CITY OF ALBUQUERQUE

**Re: Volterra Village
1624, 1828, 1632 and 1636 Domino Rd SE
Request Permanent C.O. – Not Accepted
Engineer's Stamp dated: 9-30-09 (M21D015C)
Certification dated: 5-10-16**

PLAN
SECTION
AREA DRAIN DETAIL
NTS

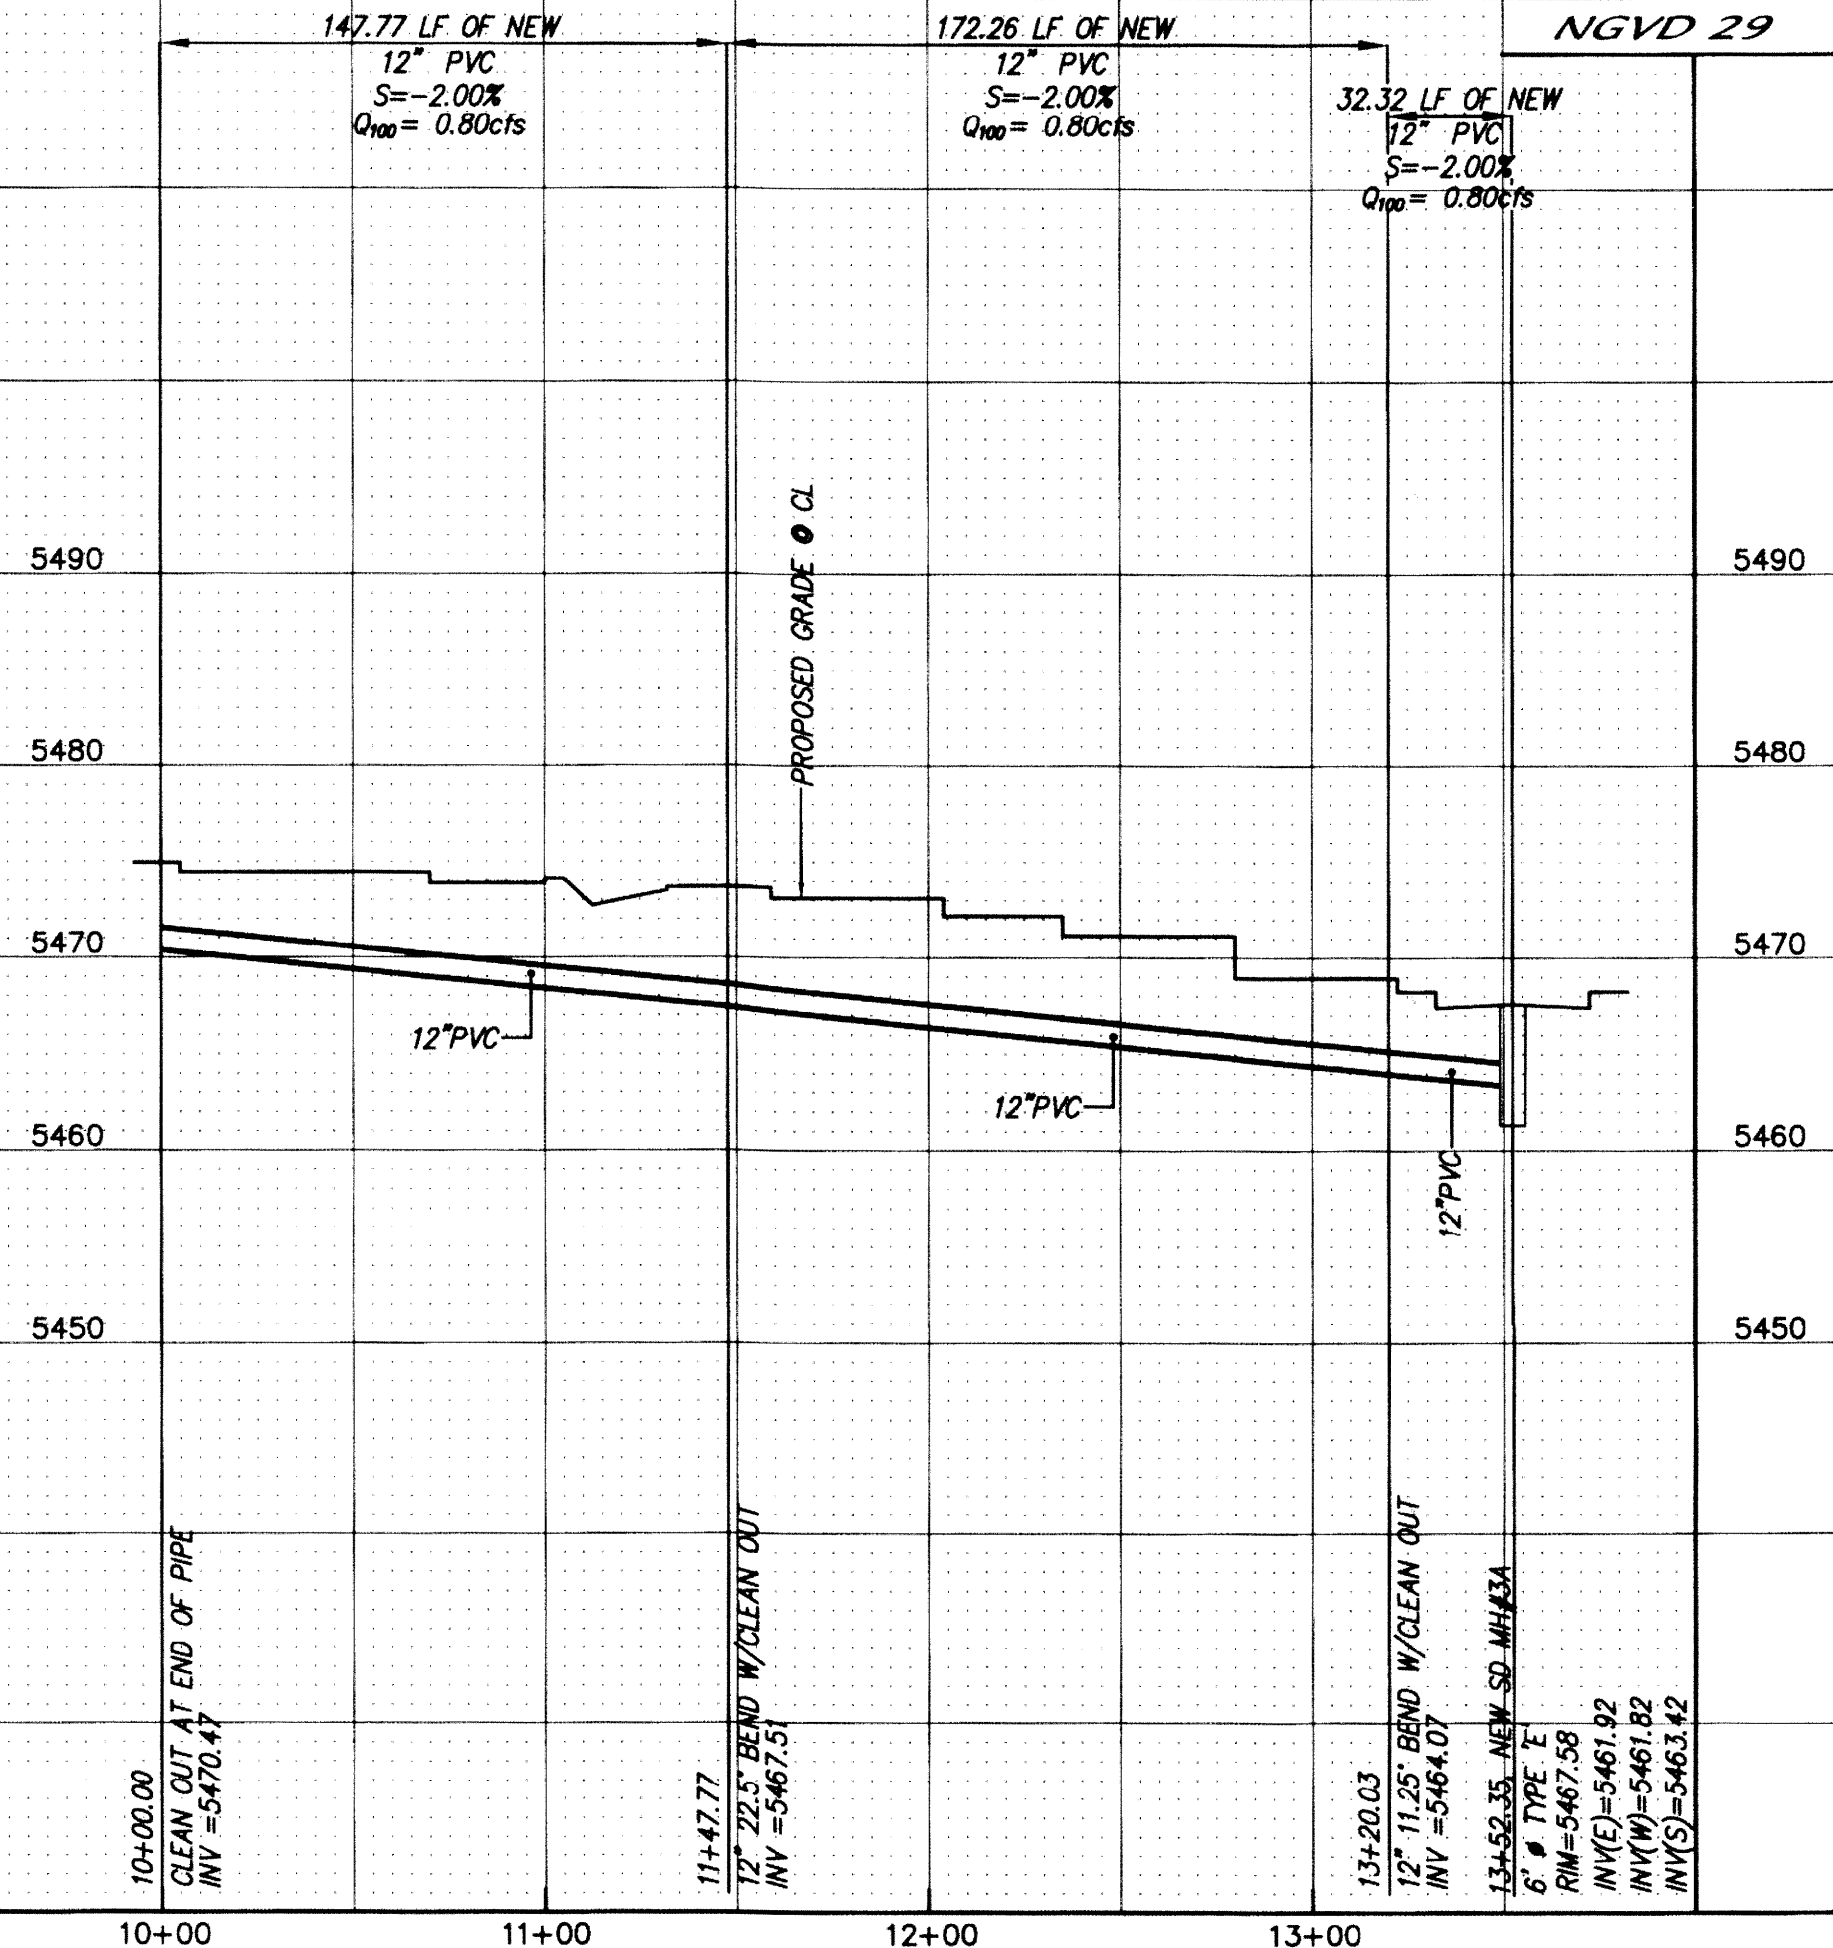
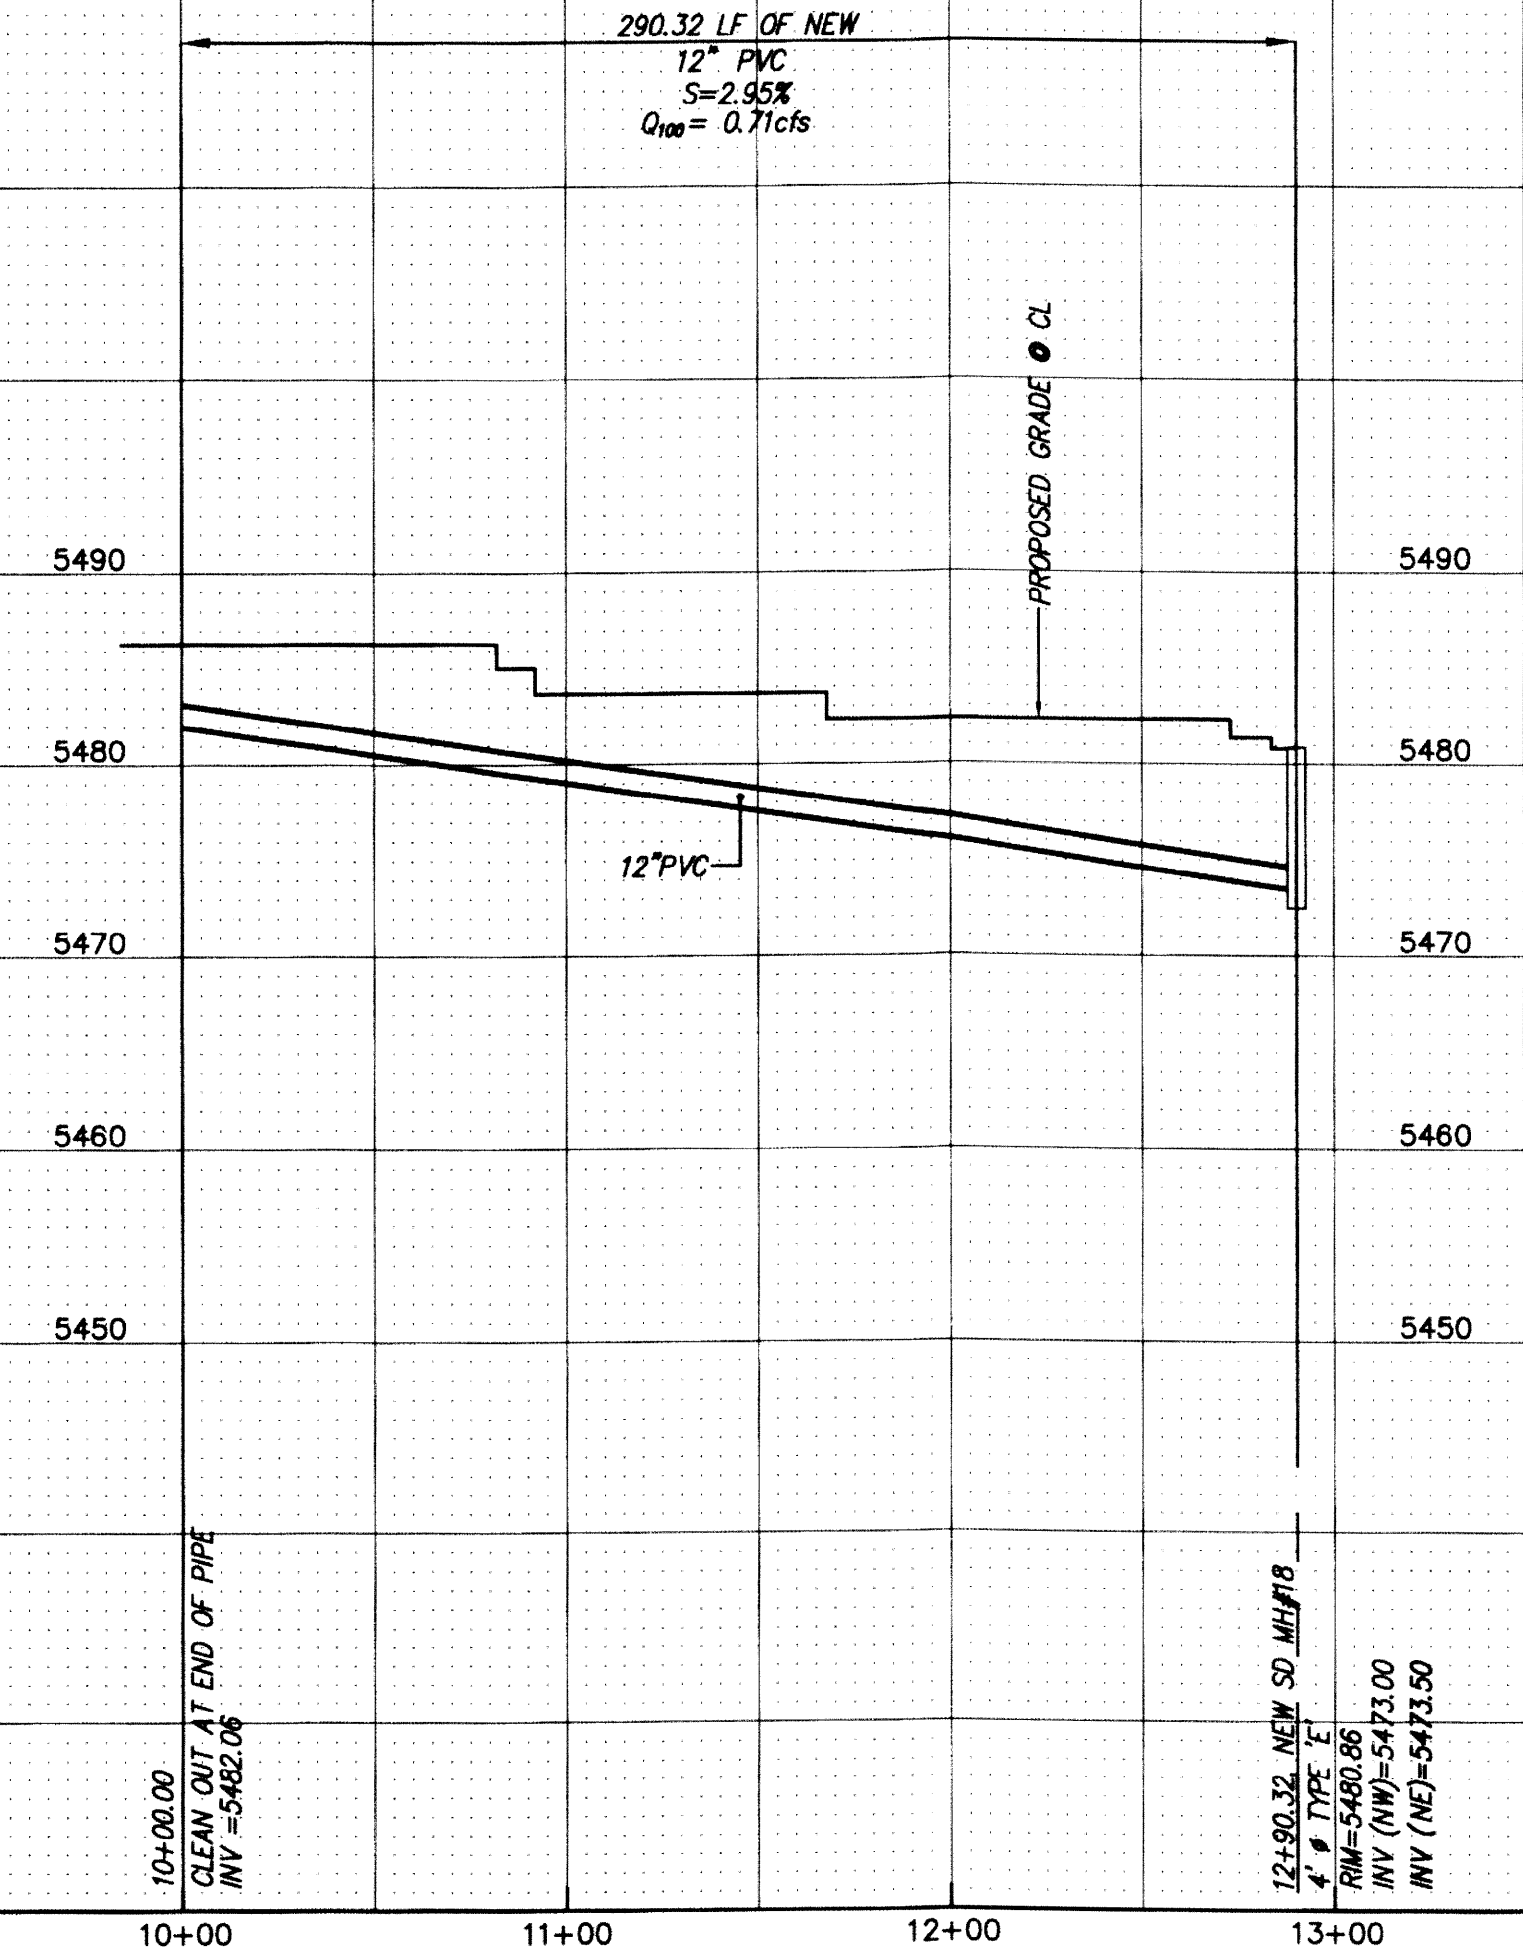
- The attached BP approval letter dated 9-10-14 states, "The drainage report required a 15" x 15" area drain in the courtyards". Per the attached pic the grates are 12" x 12". Please provide supplemental calculations that show the 12" x 12" in each courtyard is sufficient.
